Your ref:
Our ref: 21/01543/F
Please ask for: Mrs Joanne Rahman
Direct dial: 01553 616233
Direct fax: 01553 616652
E-mail: borough.planning@west-norfolk.gov.uk

Details: **Erection of a dwelling with access (on a site with an extant consent to construct a dwelling under application ref: 15/00852/F) at Apple Tree House Station Road Ten Mile Bank DOWNHAM MARKET Norfolk**

GROUND FLOOR PLAN

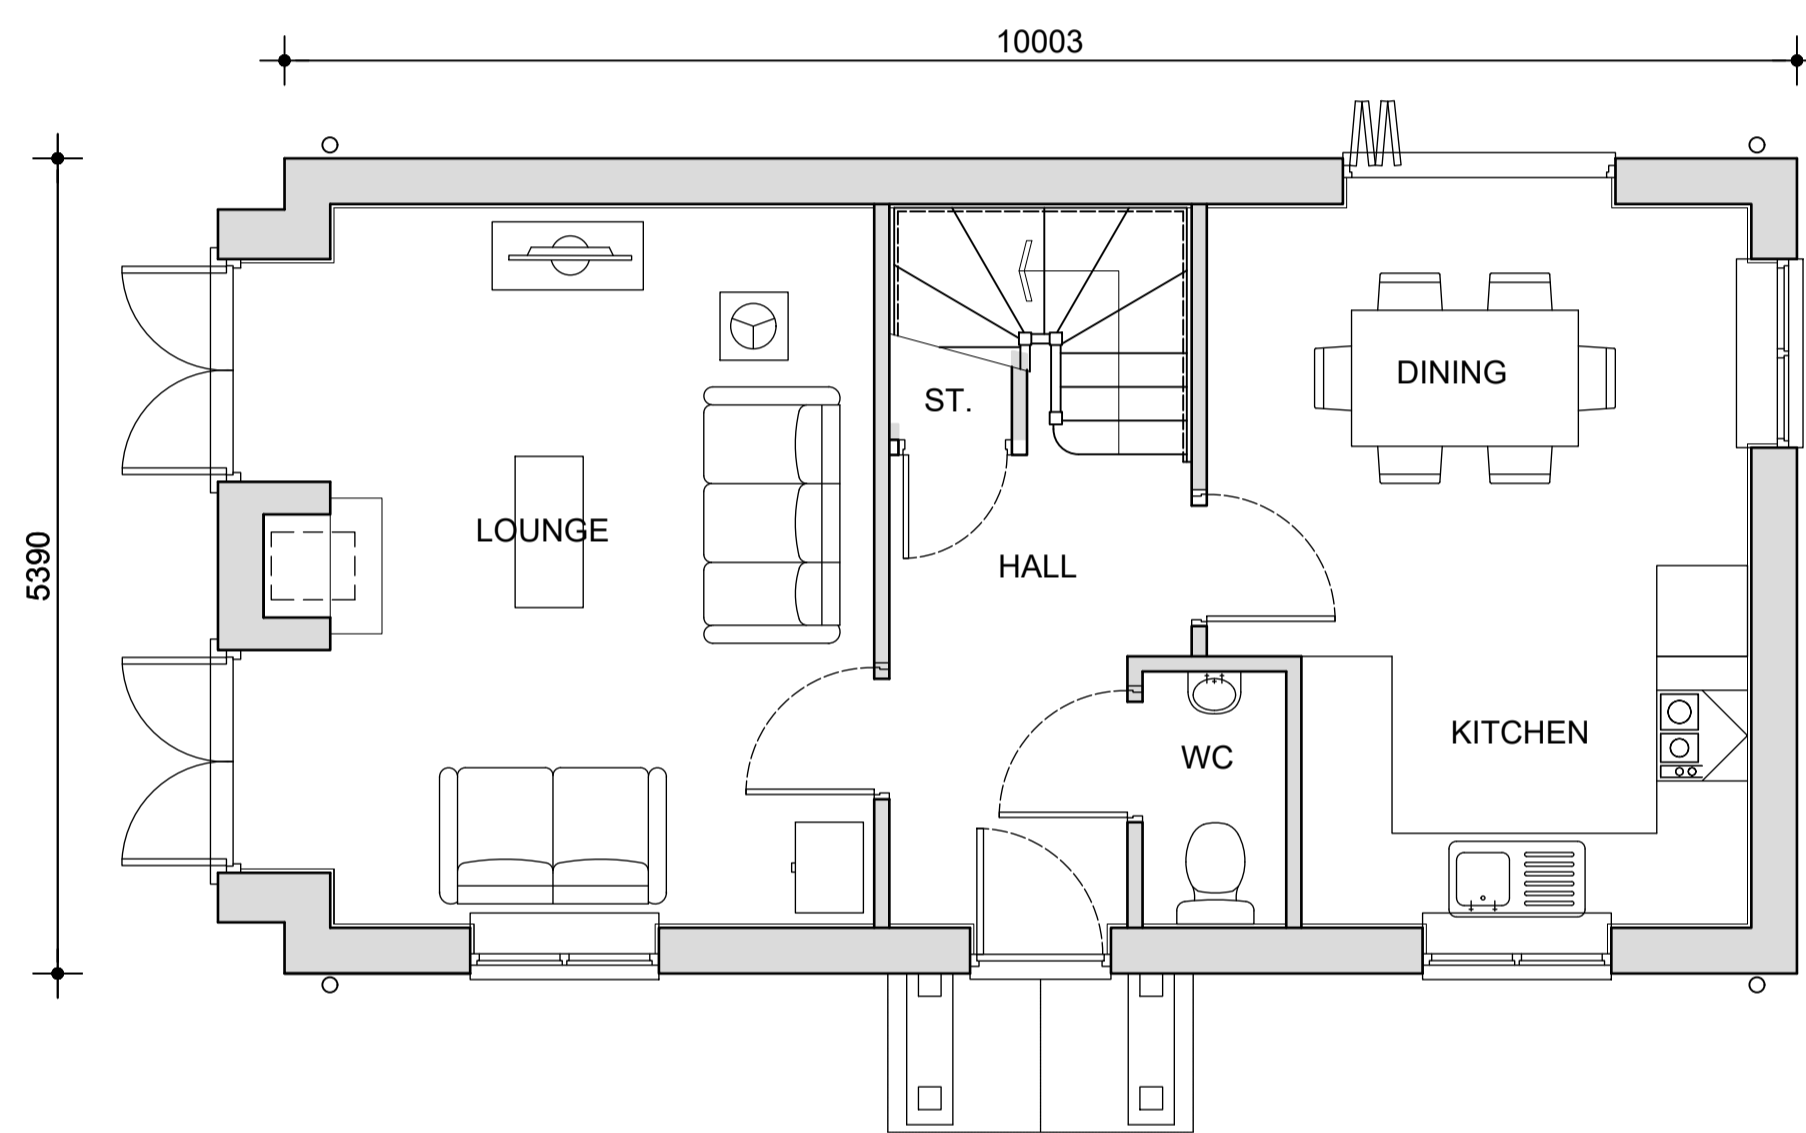
4. A Flood Risk Assessment is required to be submitted with this application, as the site lies within an area at risk of flooding.
5. As the property lies within an area at risk to flooding, please complete the simplified Matrix and return it. The Matrix can be found at https://www.west-norfolk.gov.uk/info/20173/information_for_planning_agents/231/flood_risk_information
6. Please submit a section through of the proposed dwelling, this should be done to a scale of 1:50 or 1:100.
7. There is a door shown on the proposed ground floor plan that is not on the proposed rear elevation. Please amend and resubmit the correct plan.
